Response to Planning application from Hertfordshire County Council (T and CP GDP Order 2015)

District ref: 6/2021/3440/FULL
HCC ref: WH/10666/2022
HCC received: 18 January 2022
Area manager: Matthew Armstrong
Case officer: Paul Marshall

50 PLOUGH HILL CUFFLEY POTTERS BAR EN6 4DS

Erection of gate and formation of new hardstanding and dropped kerb

ELEVATIONS FOR GATED WALL and ROAD PROPOSAL

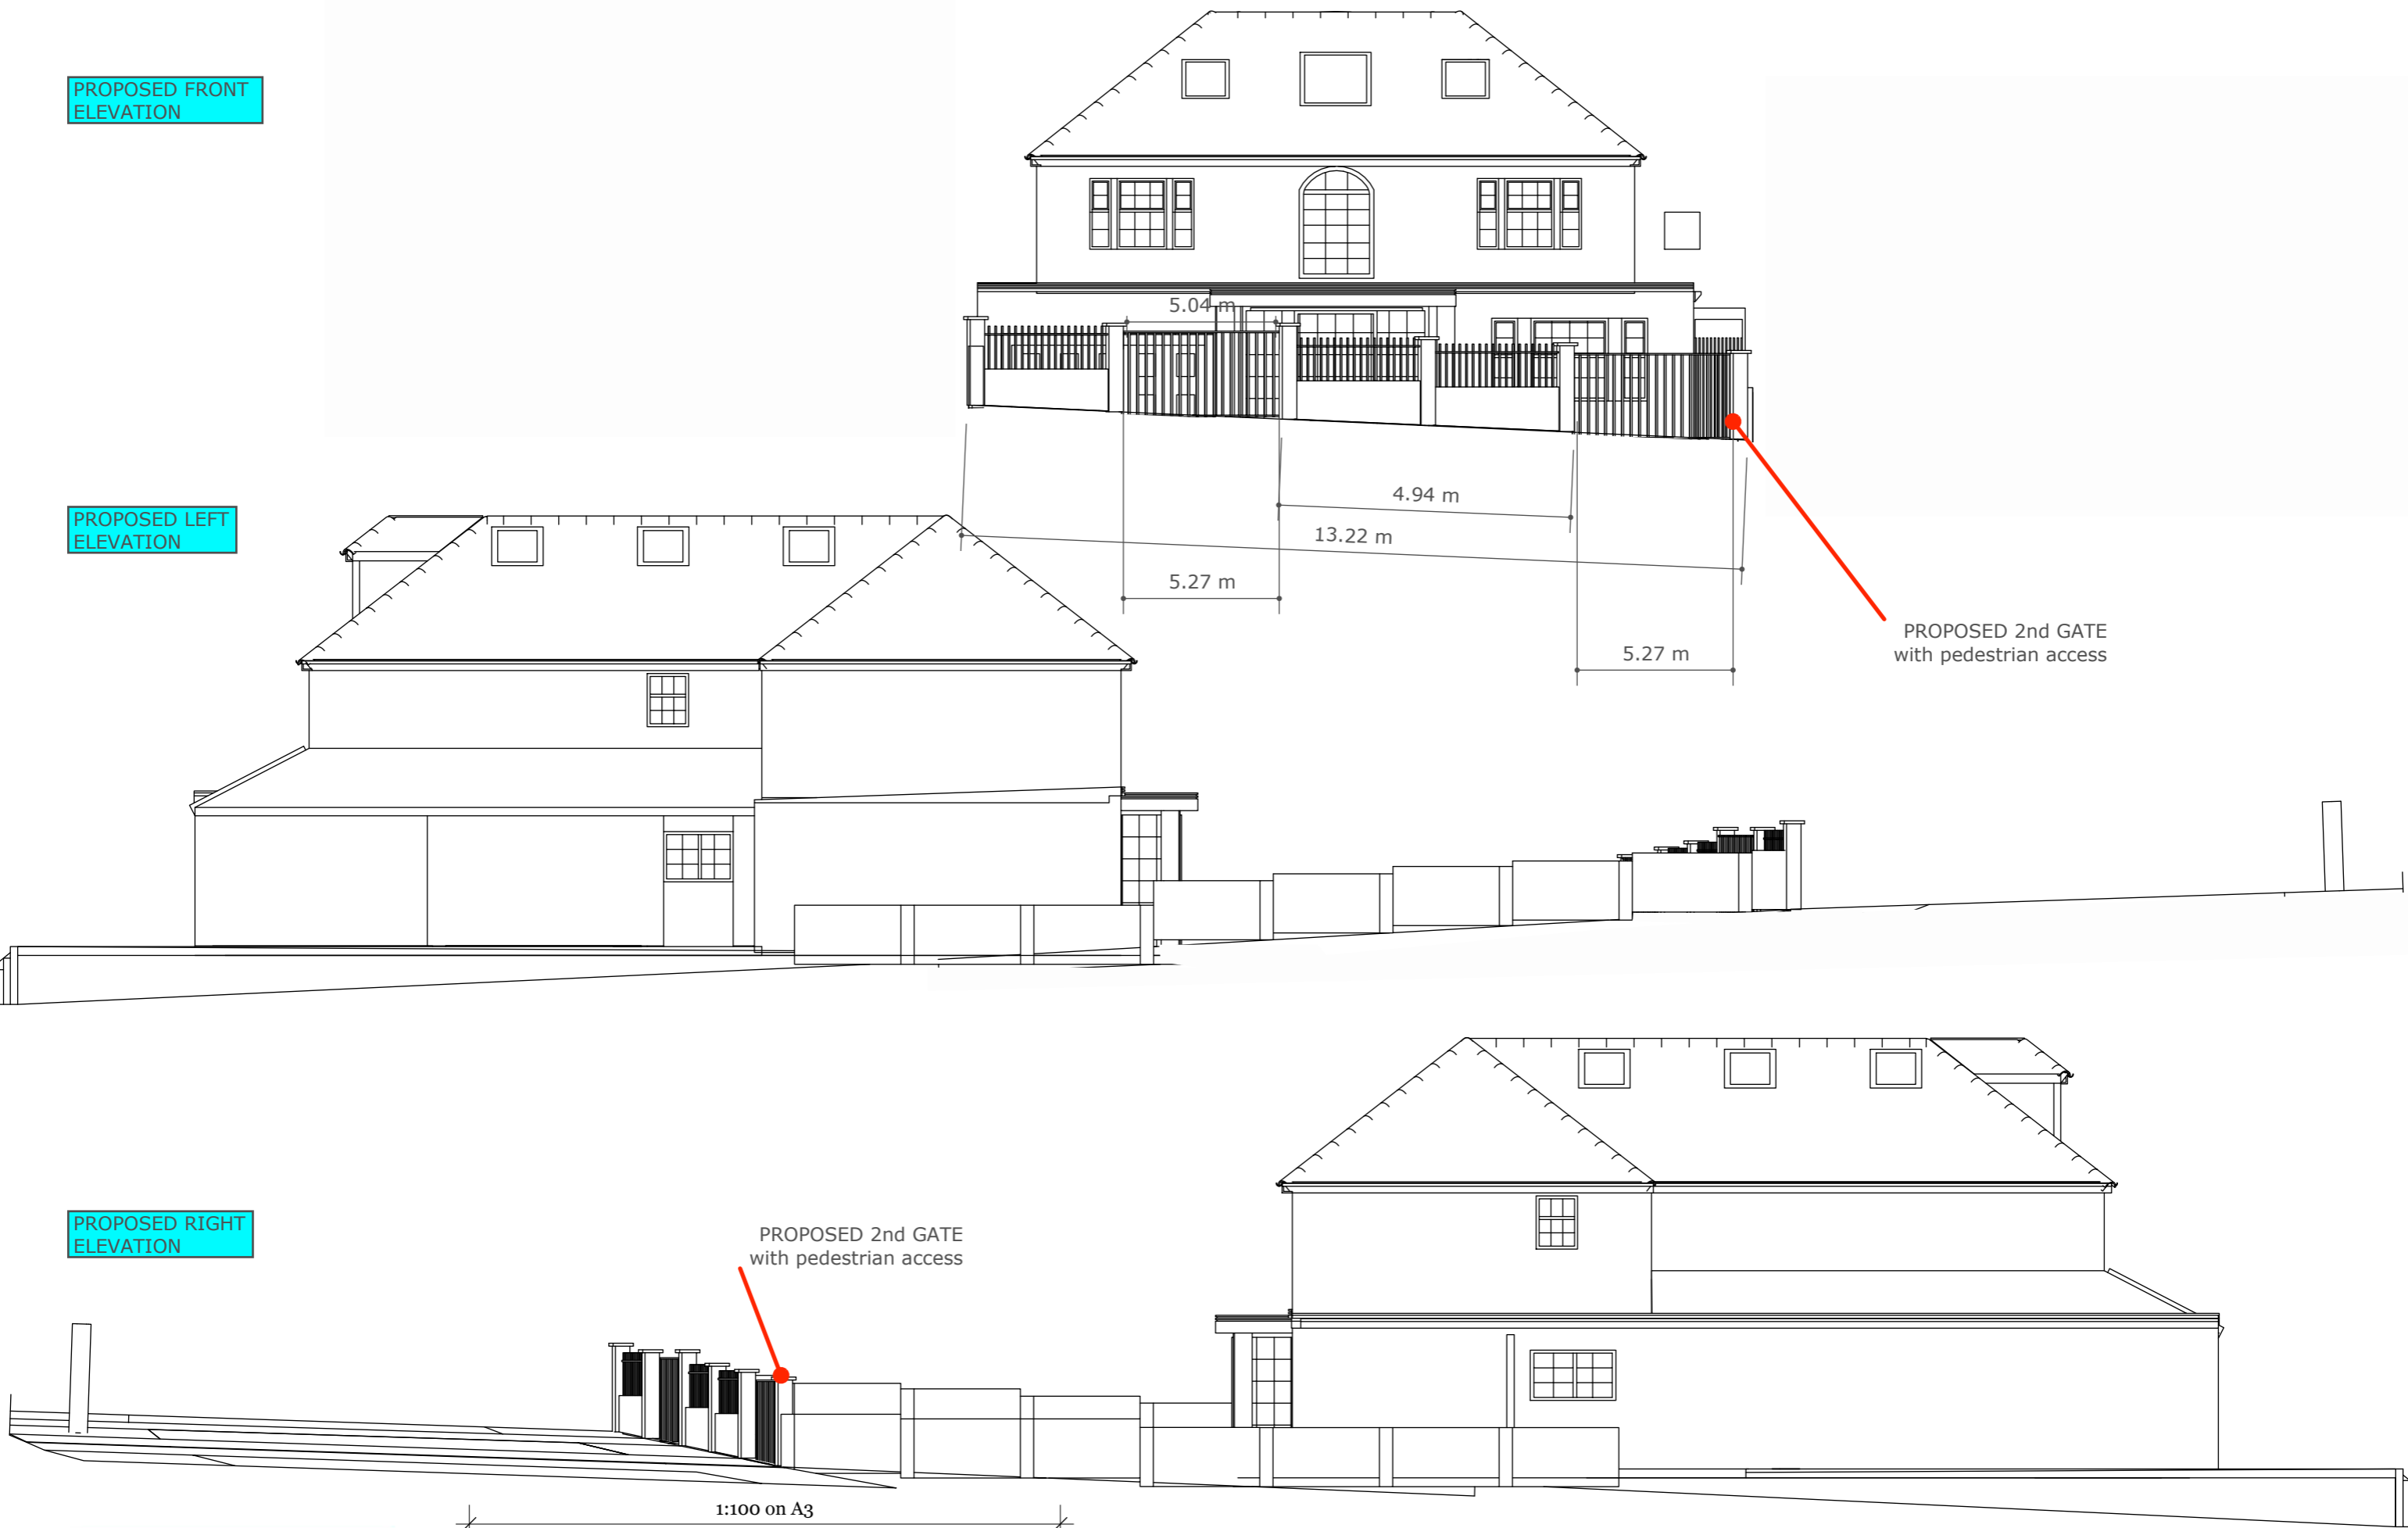
The proposed dropped kerb is too long

Please find also Hertfordshire County Council's Dropped Kerbs (Residential Crossovers) Guidance. <https://www.hertfordshire.gov.uk/droppedkerbs/>. For information if your property already has a dropped kerb, we will only extend or widen it to a maximum of 5.4m. This is the widest dropped kerb that we will allow and equates to a maximum of 4 dropped/flat kerbs and a maximum of 2 ramped kerbs. We will not install any more than 4 flat kerbs. Please do not apply for a dropped kerb wider than this as it will be refused.

This also applies where an access serves two dwellings as in this application.
